Draftline Services

Reference; Proposed Dormer Bungalow to rear of 2, St. Lukes Way, Monk Bretton,
Barnsley S71 2HB for Mr M.Bloomfield. App No 2010/0002

Yorkshire Water Sewer within 3metres ref; L000118 dated 28th January 2010

PROPOSED ELEVATIONS 1/100

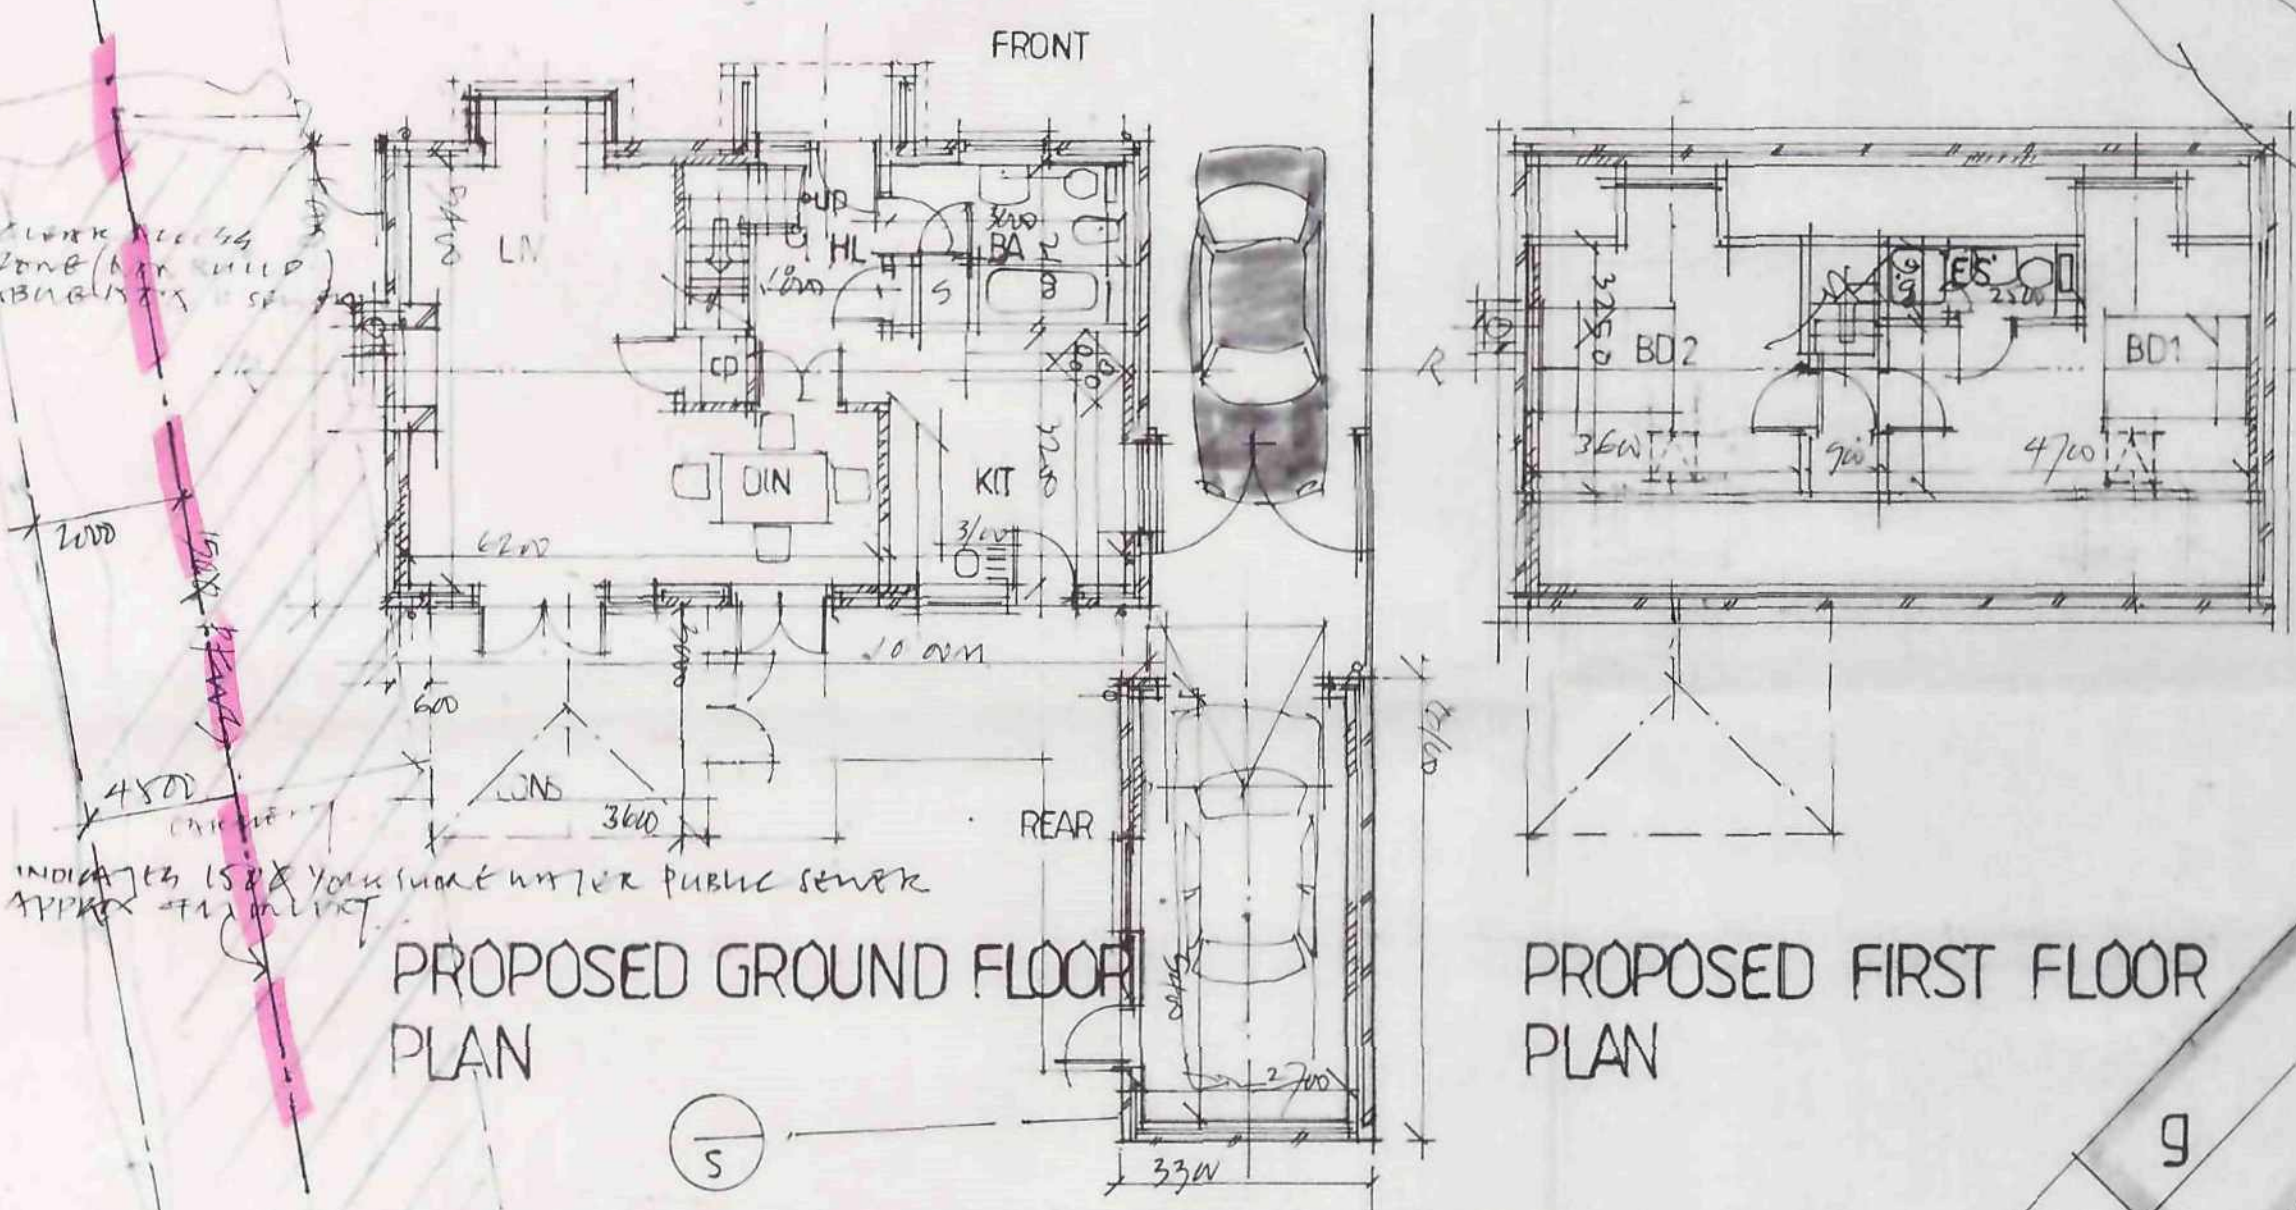
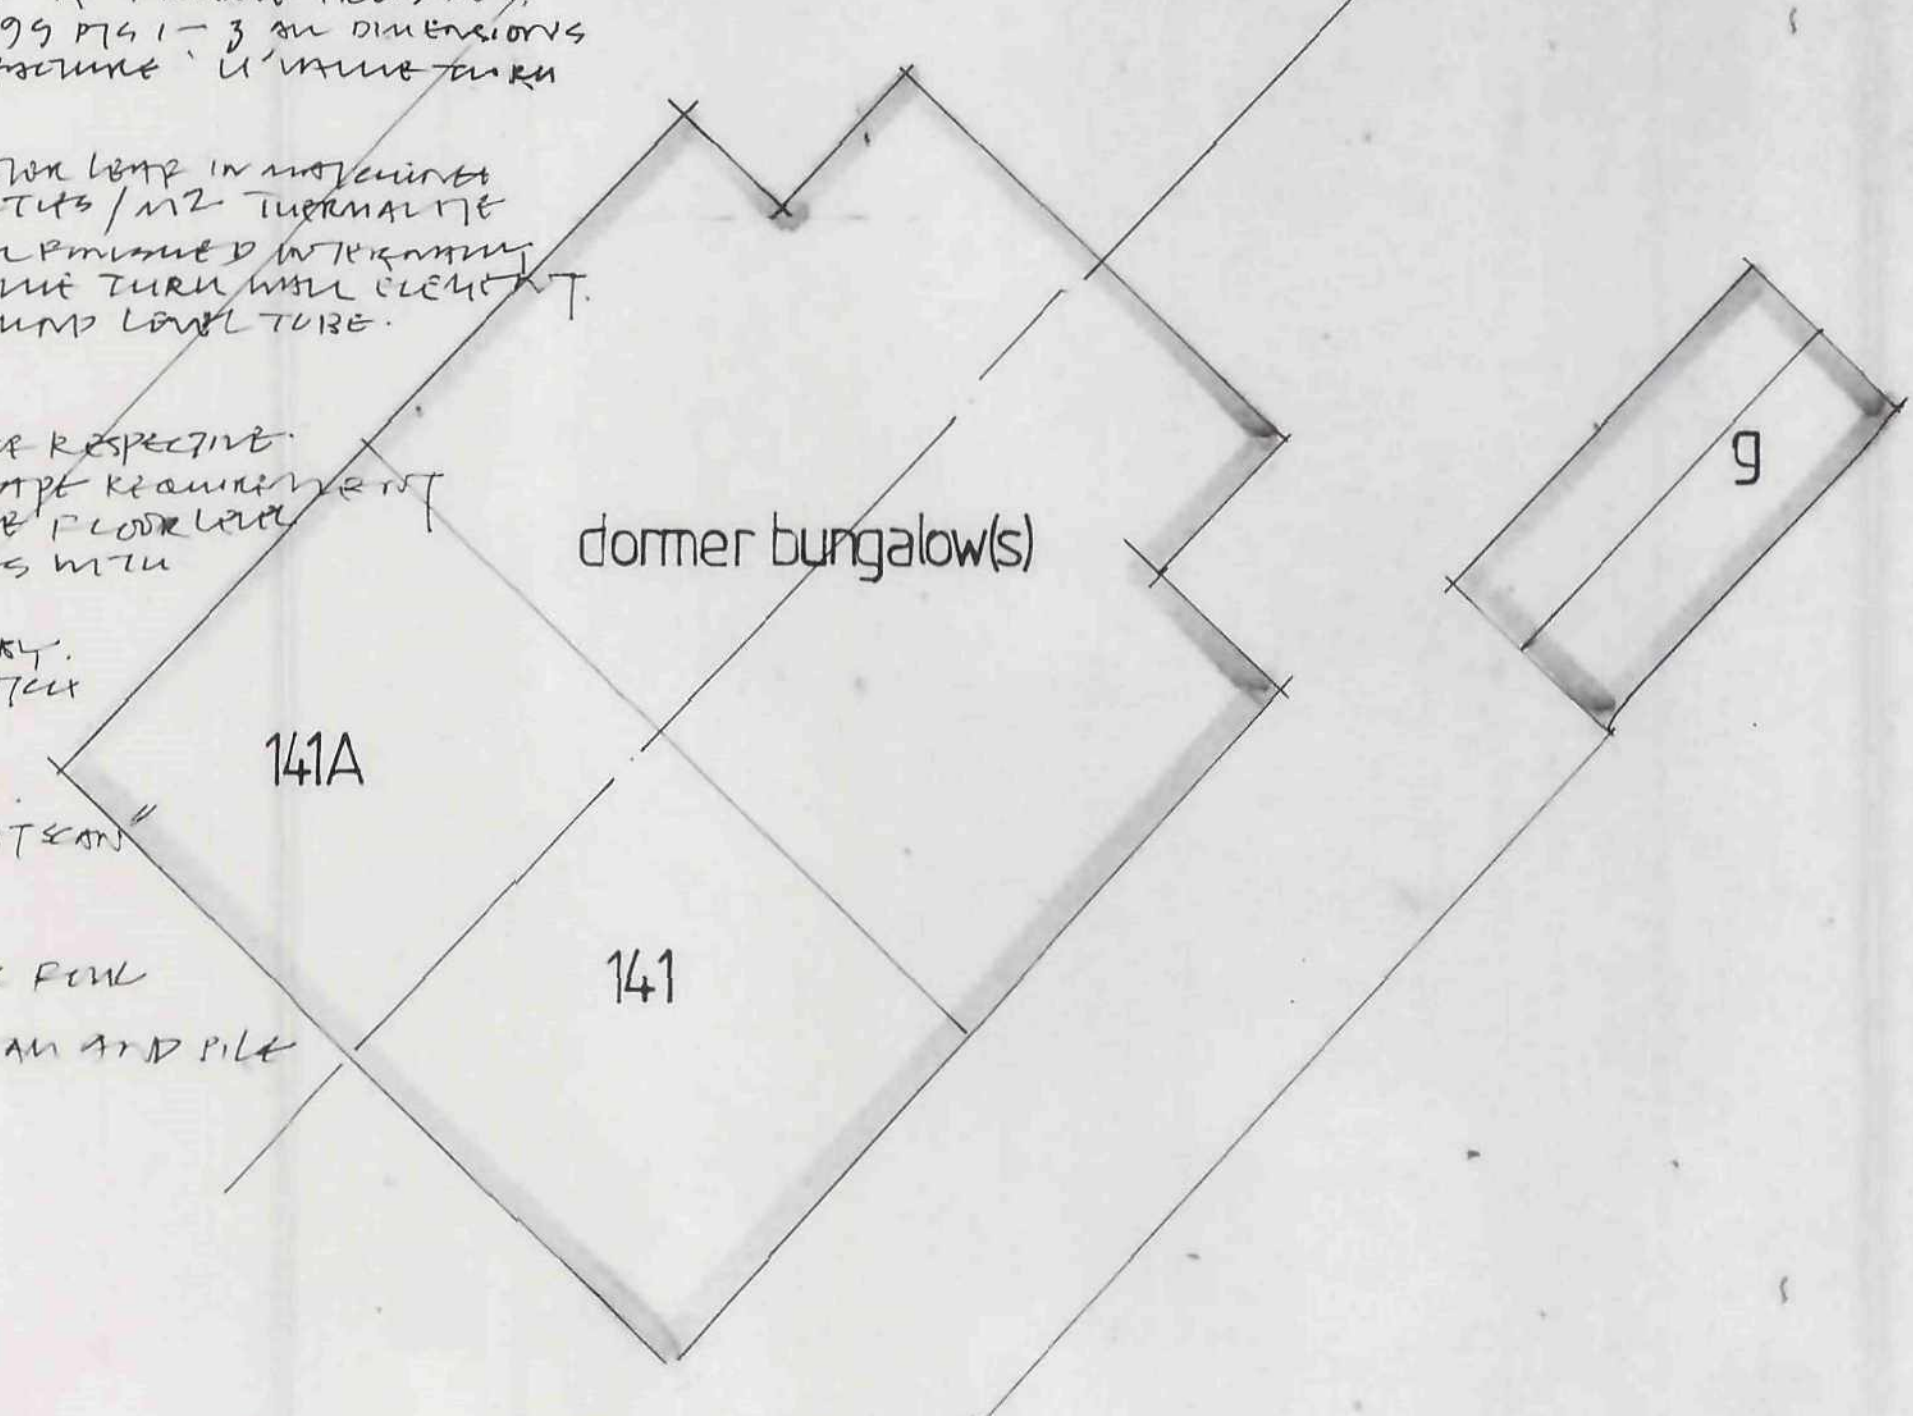
Please find for your comment and file ;position sive of sewer crossing the rear of the above site @ approx 4m depth.

Corrective Foundation design being to build the proposed Bungalow on a concrete raft or beam and pile construction and therefore not causing any further positive loading to the 150 dia foul sewer.
